Planning Application AW/281/11/

Erection of large Garage/Out building at 69 The Fairway, Aldwick Bay, Bognor Regis

Re: planning application AW/281/11

Drwg Title:
Proposed
Work

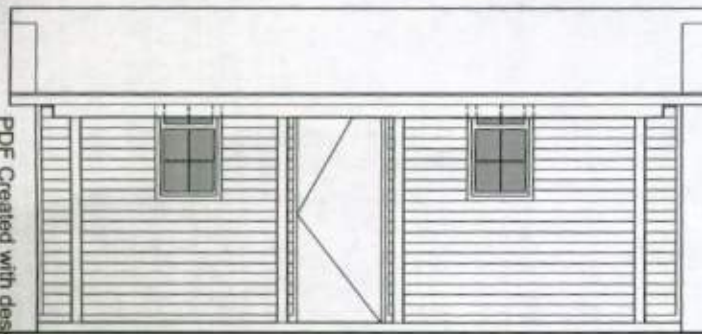
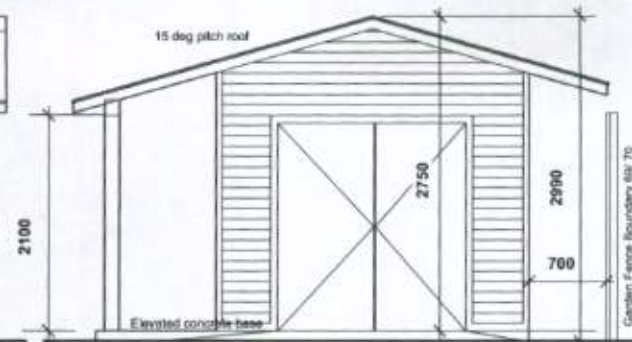
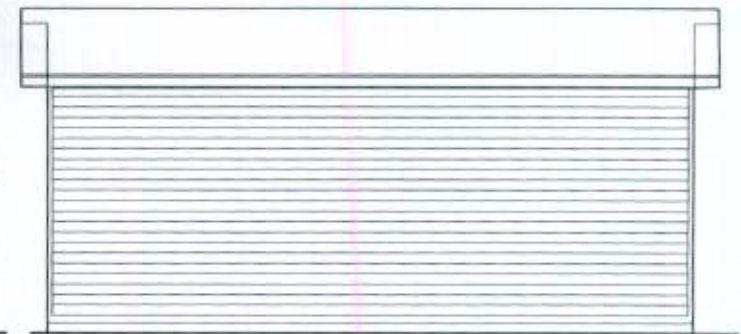
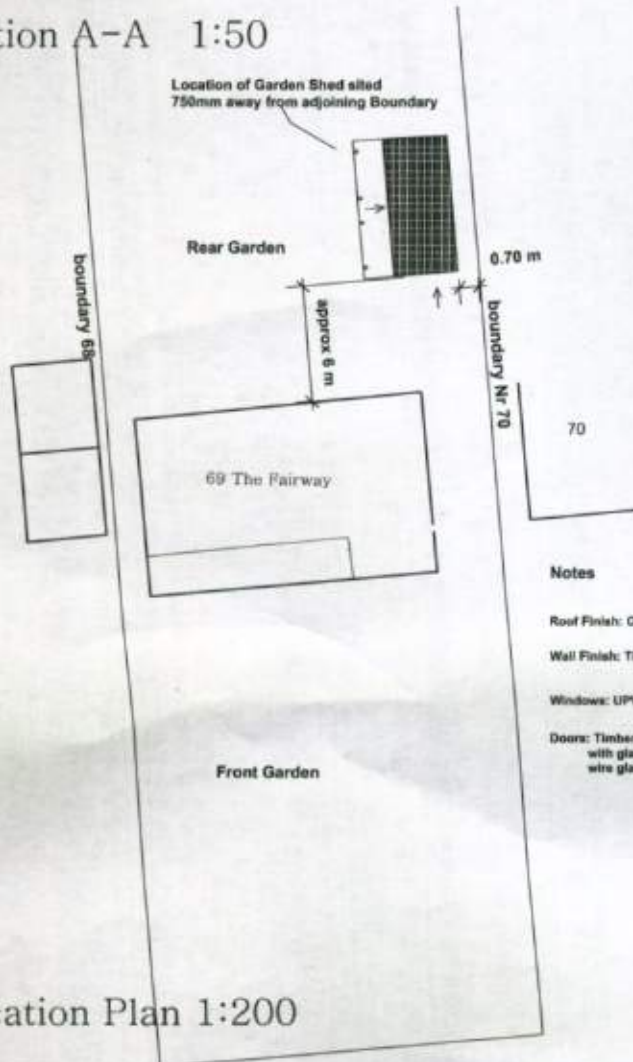
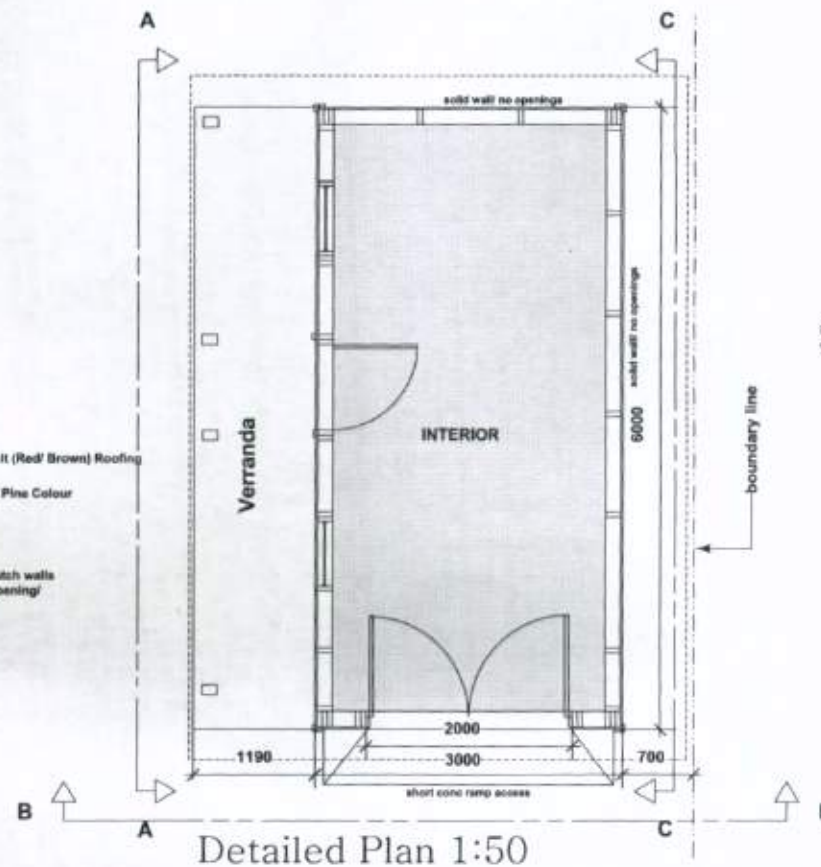
We wish to strongly object to the erection of a very large (6 meters long by 3 – 4 meters wide and 3 meters high at the apex) wooden garage/outbuilding at the rear of no 69 The Fairway.

The building is too close to our boundary. The wall is less than half a metre away, and the roof fascia is actually over the boundary fence and we are concerned about the potential fire risk to our property of having such a large timber building so close to our house if it were to catch fire.

The building is also 3 metres high and as it is due west of our house and so close to the boundary will block out a lot of light from our garden and our living room in the evening.

We would like the building to be moved further away from the boundary so that no part is nearer than a meter to the boundary as we believe is required by the building regulations.

As it is so close to the boundary we would also like the height restricted to a maximum 2.5 metres to reduce the loss of amenity.
